Historic England

25 October 2024

**THOMAS COWLEY HIGH SCHOOL, SCHOOL LANE, DONINGTON, SPALDING,
PE11 4TF**

Application No. H04-0199-24

DRAWN BY EK	CHECKED BY EMA	DATE February 2024
SCALE 1:100 @ A1	PROJECT NUMBER 2404	
DRAWING NUMBER PP100	REV 04

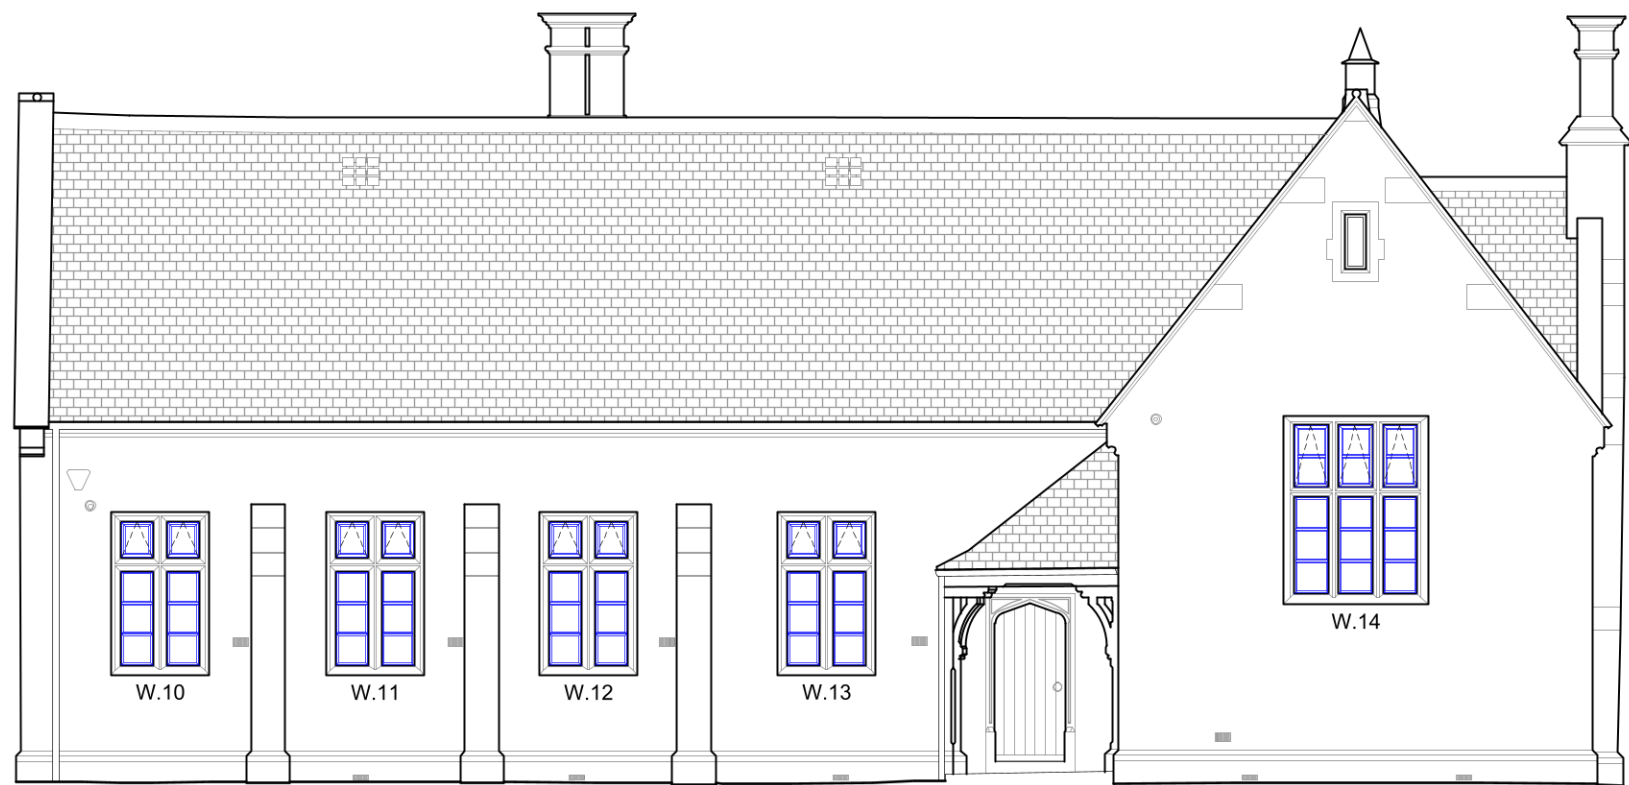
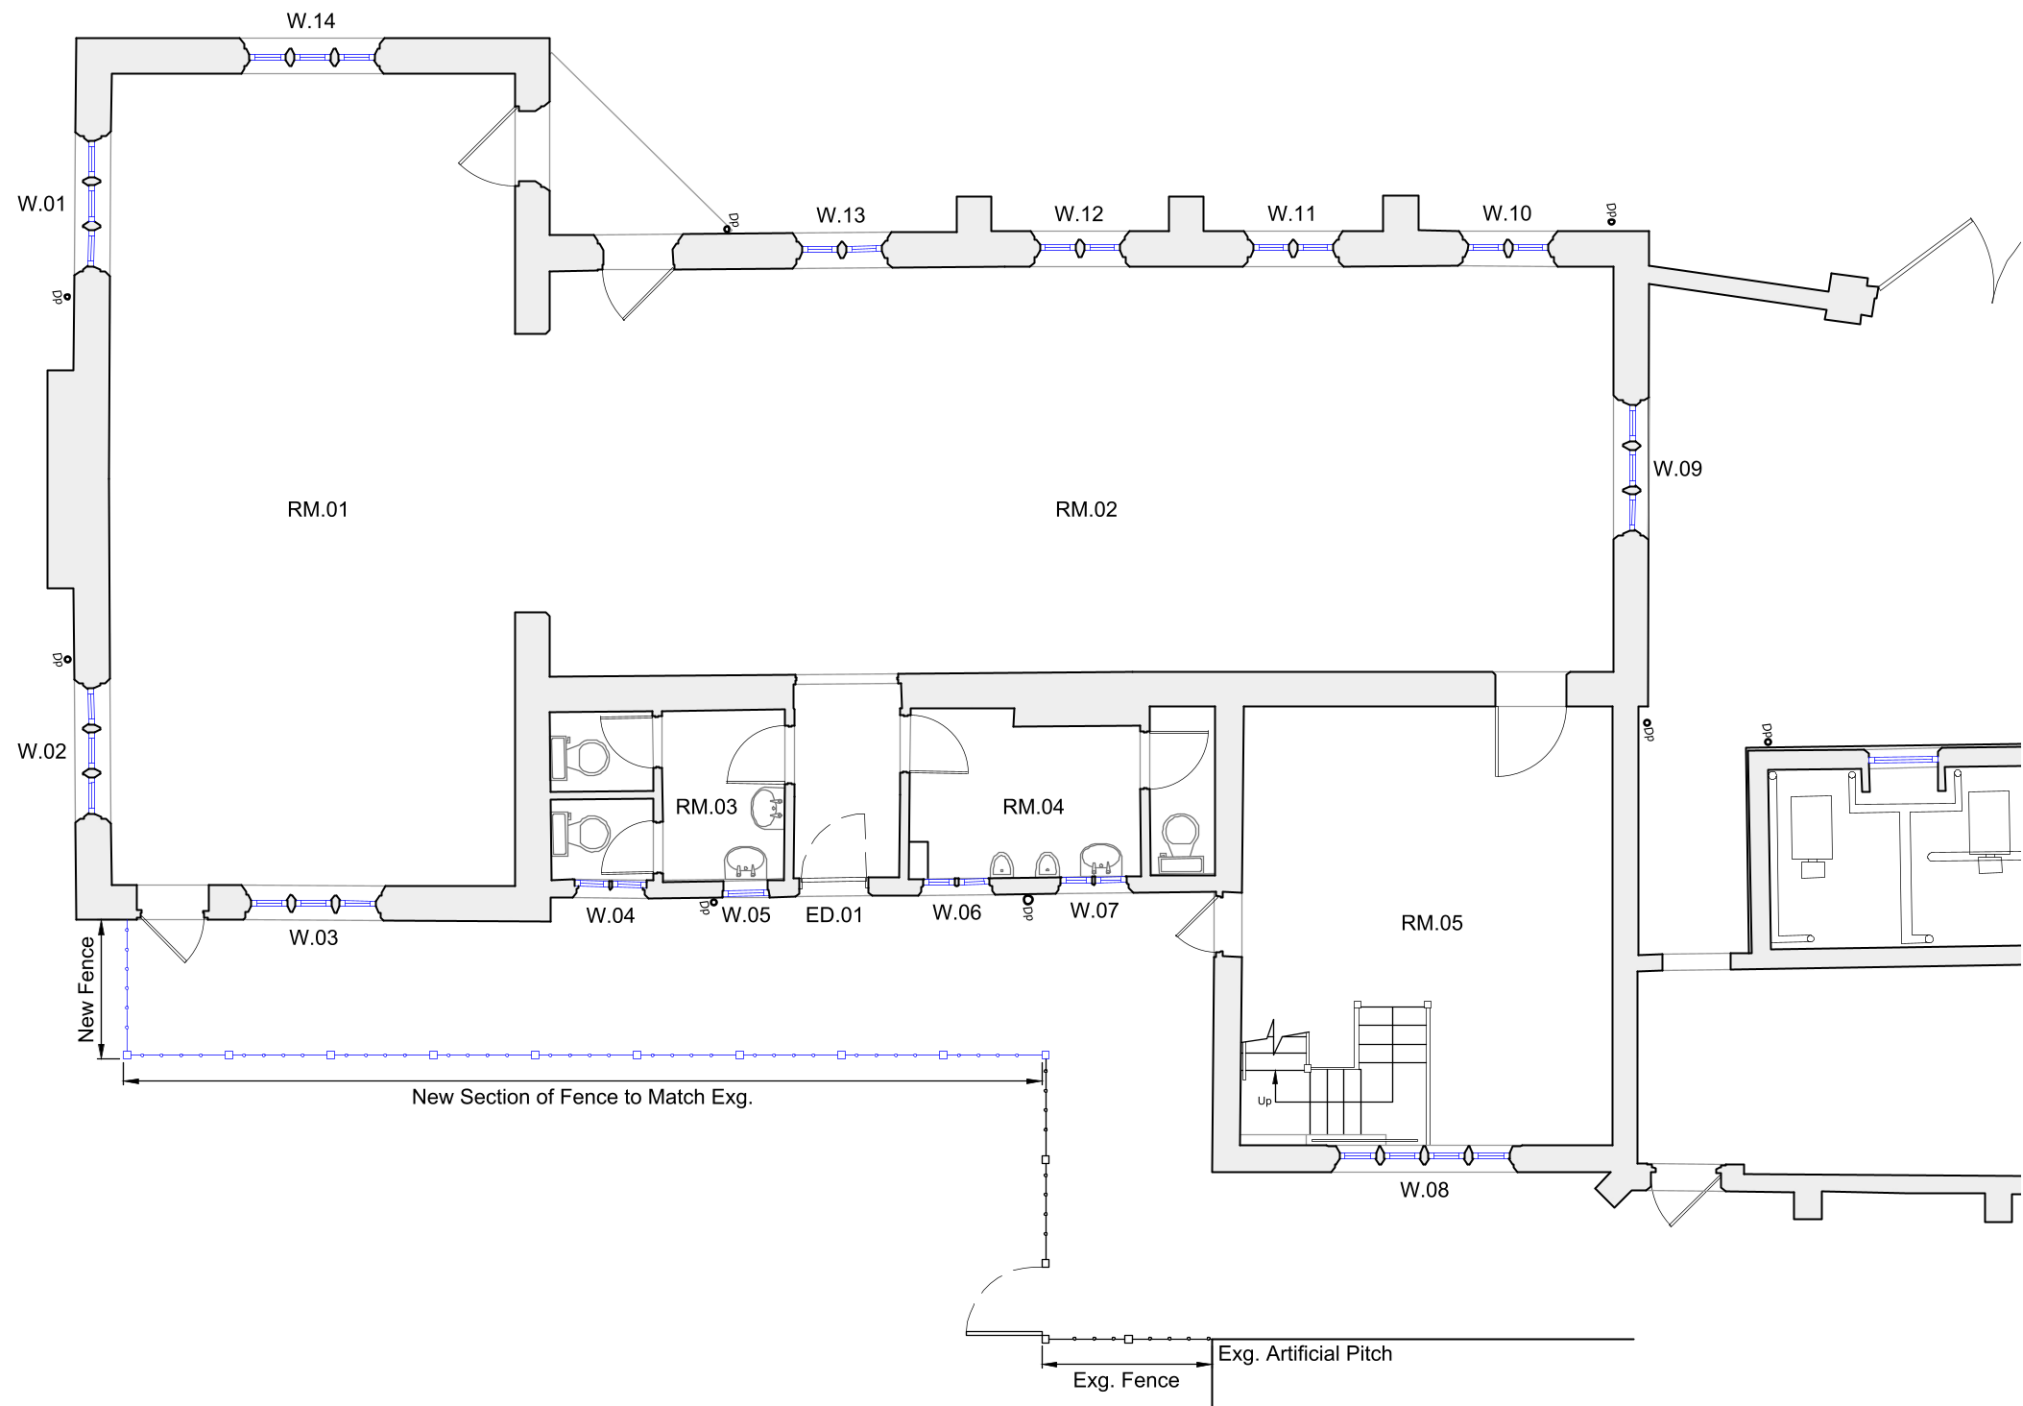
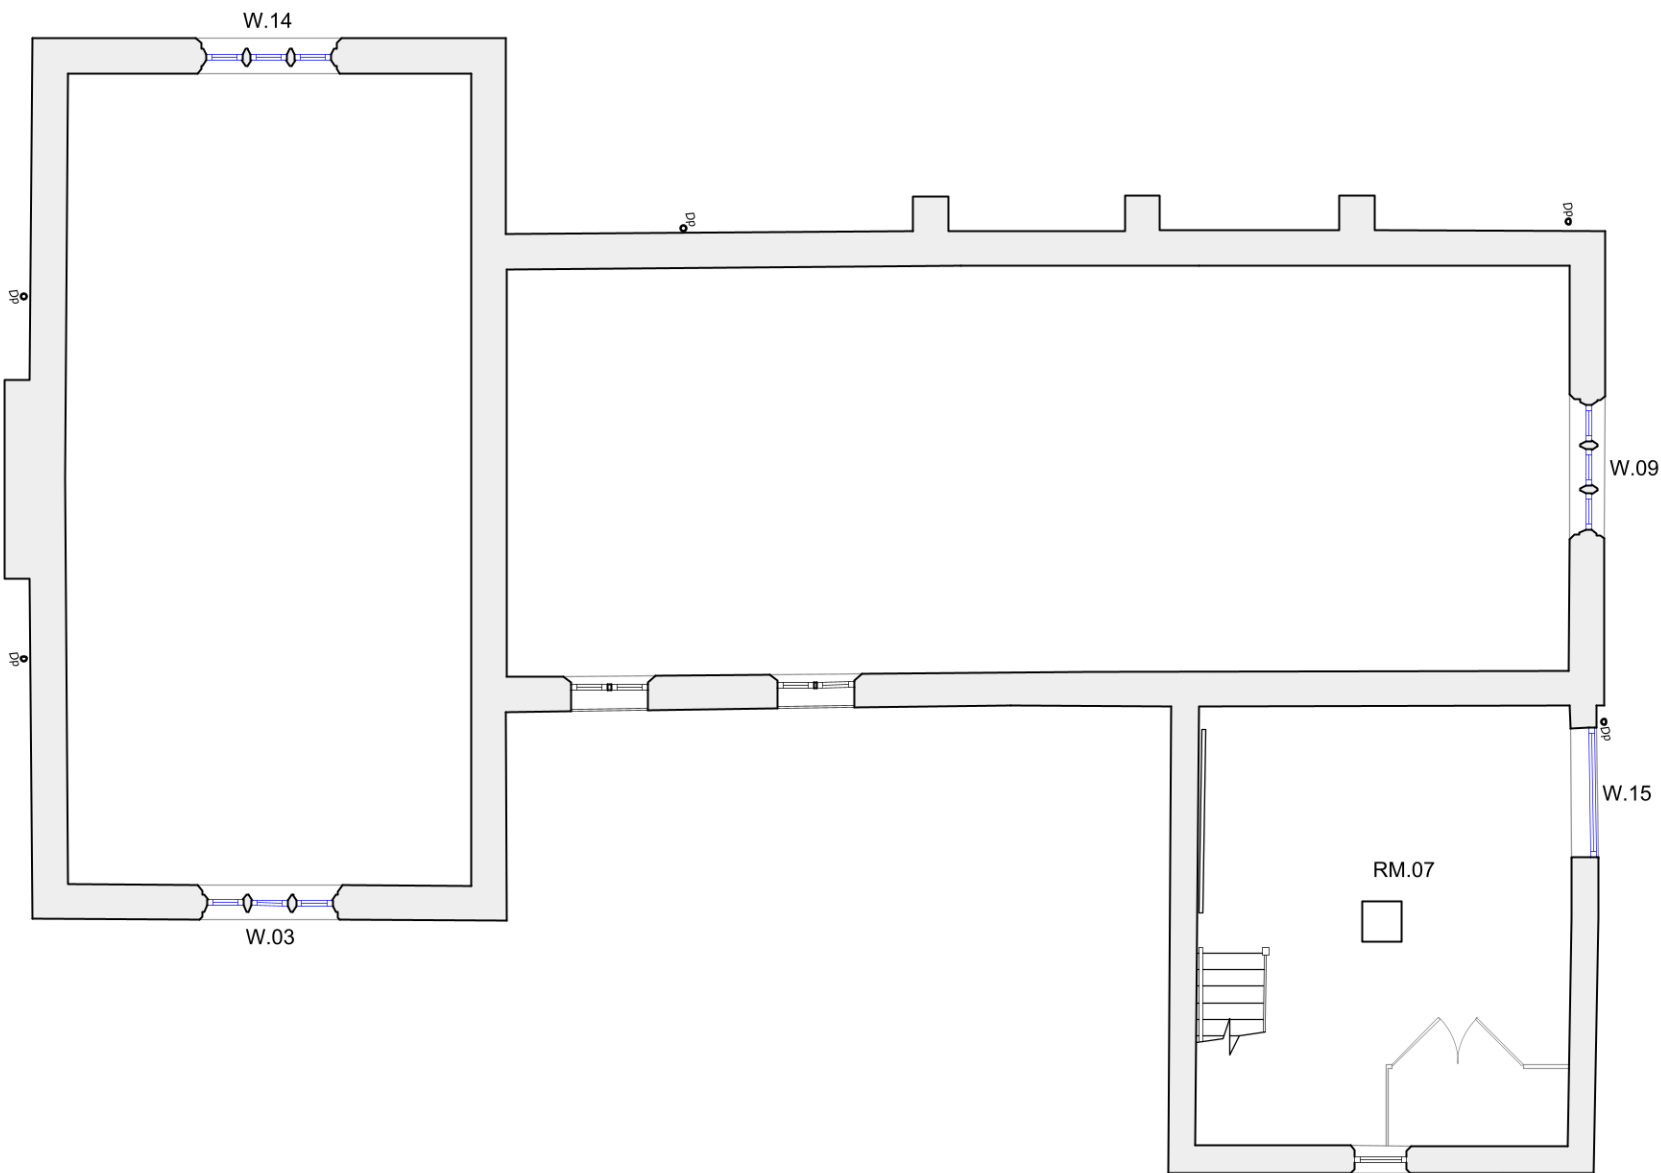
Historic England note the positive changes to the scheme after the omission of planned internal works, which ensure that the interior of the building will continue to be experienced as an historic structure. The amended plans still propose to replace all existing timber framed windows in aluminium, to match the existing layout. Historic England has concerns regarding this element of the application.

The building is listed Grade II in light of its historical and architectural interest. The proposal to replace 15 windows would result in a lot of fabric loss.

The submitted Heritage Statement does not elucidated the age of the existing windows or the contribution they make to the overall significance of the listed building. The Heritage Statement also notes that 'the windows are of an overall poor condition with several windows deteriorating to a state beyond economical repair and are therefore in need of replacement', however the submitted documentation does not provide details of the condition of all windows to be replaced.

Therefore, without sufficient information about the significance of the windows and their condition, their removal has the potential to cause harm to the significance of the listed building. As noted in our previous advice dated 05 April 2024, the choice not to reproduce, repair or upgrade the windows in timber requires justification.

We recommend that further information is provided to your Conservation Officer about the significance and condition of the windows and the justification for their replacement, to enable them to make an informed assessment of heritage impact.

We also encourage the consideration of repairing and retaining windows as far as possible, and if windows are deemed non-salvageable, a suitable condition assessment should be provided. Where certain windows are in need of full replacement, the proposed like-for-like replacement is acceptable.
